# PORTLAND MAINE

January 4, 2005

Re: Permit# 041423 (017 E003)

This office has reviewed the sketch dated 12/23/04 and have the following questions/comments:

72 Waterville St - front 2<sup>nd</sup> floor entrance/deck

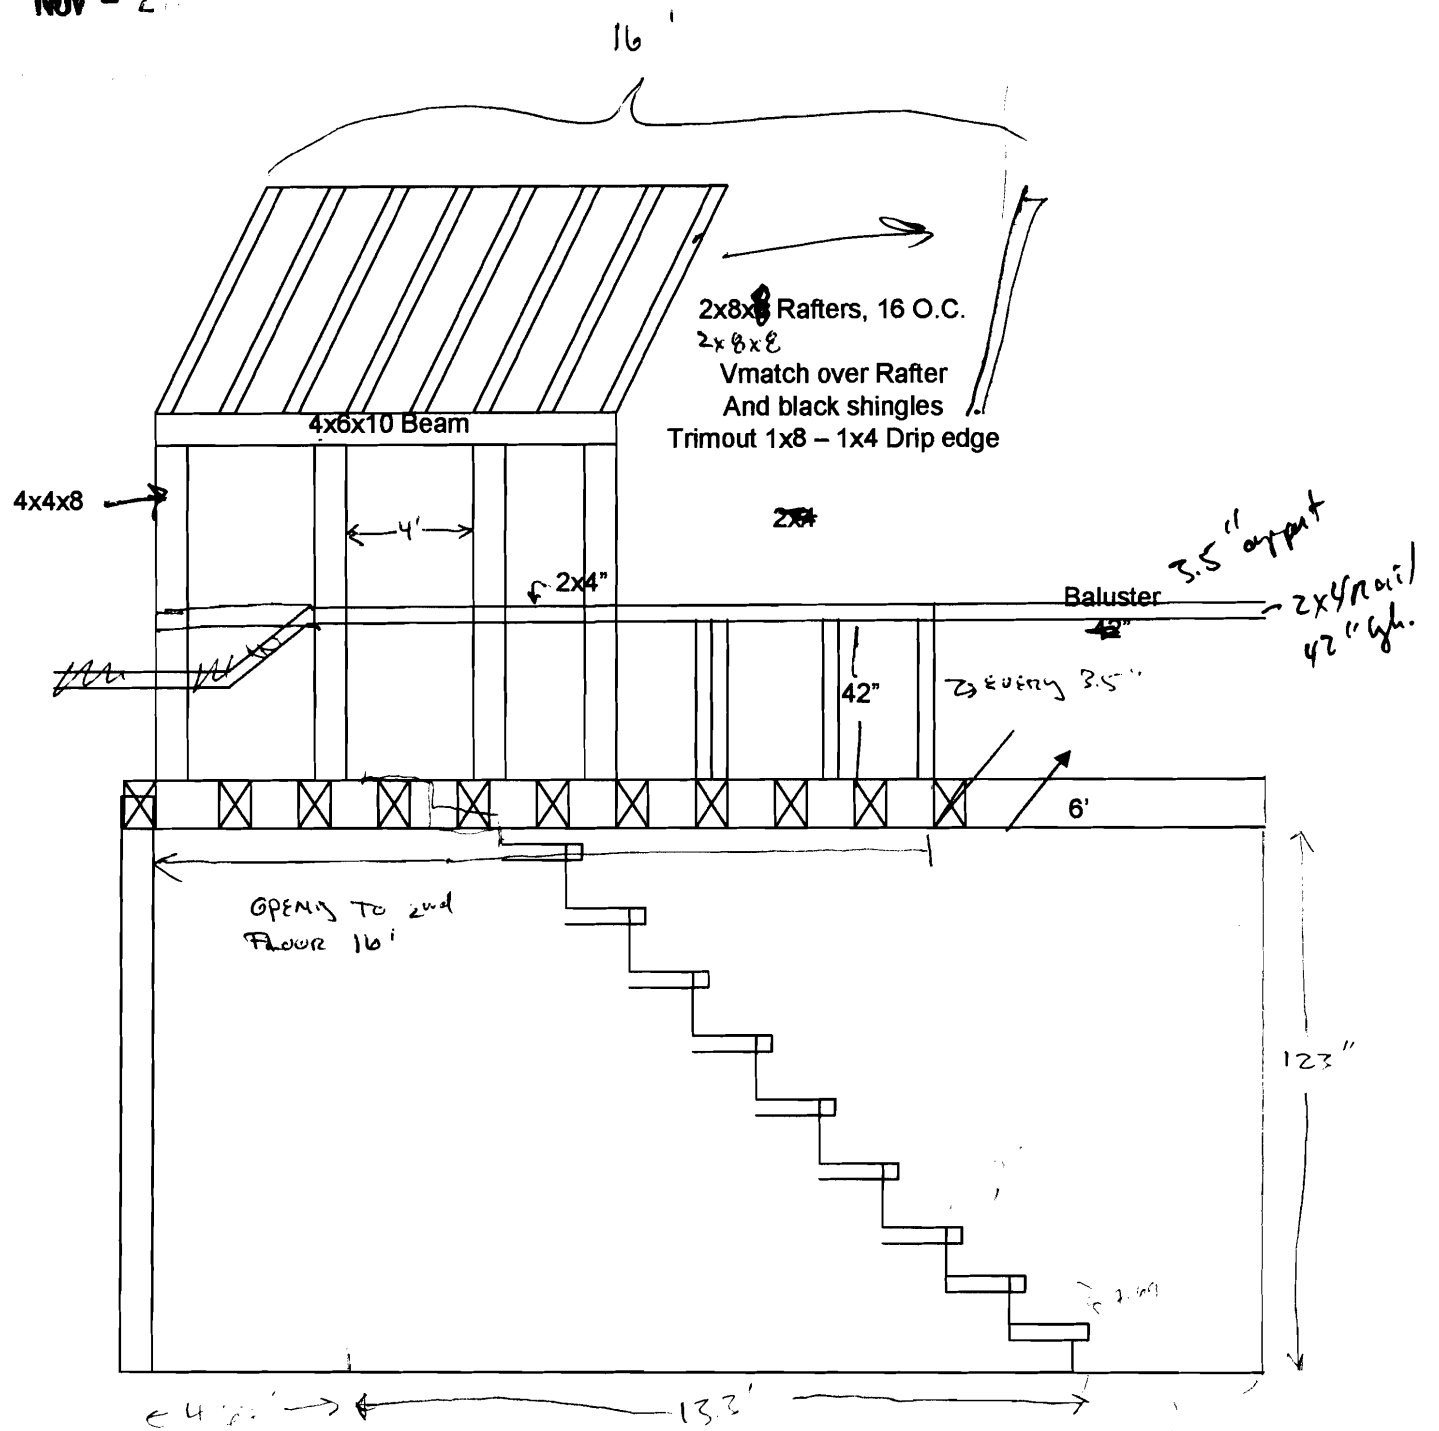
- 1) The resulting 32 inch exit access from the First Floor unit is not allowed by the Building or Fire Prevention codes.
- 2) If the stairway is not "within a dwelling unit" the net tread must be at least 11 inches and the net rise cannot exceed 7 inches.
- 3) The headroom measurement must be as shown in the attached commentary figure 1009.2. If your project were constructed as proposed, it may violate required headroom.
- 4) Need framing details for the deck, the stairway opening, the stairway, guards etc.
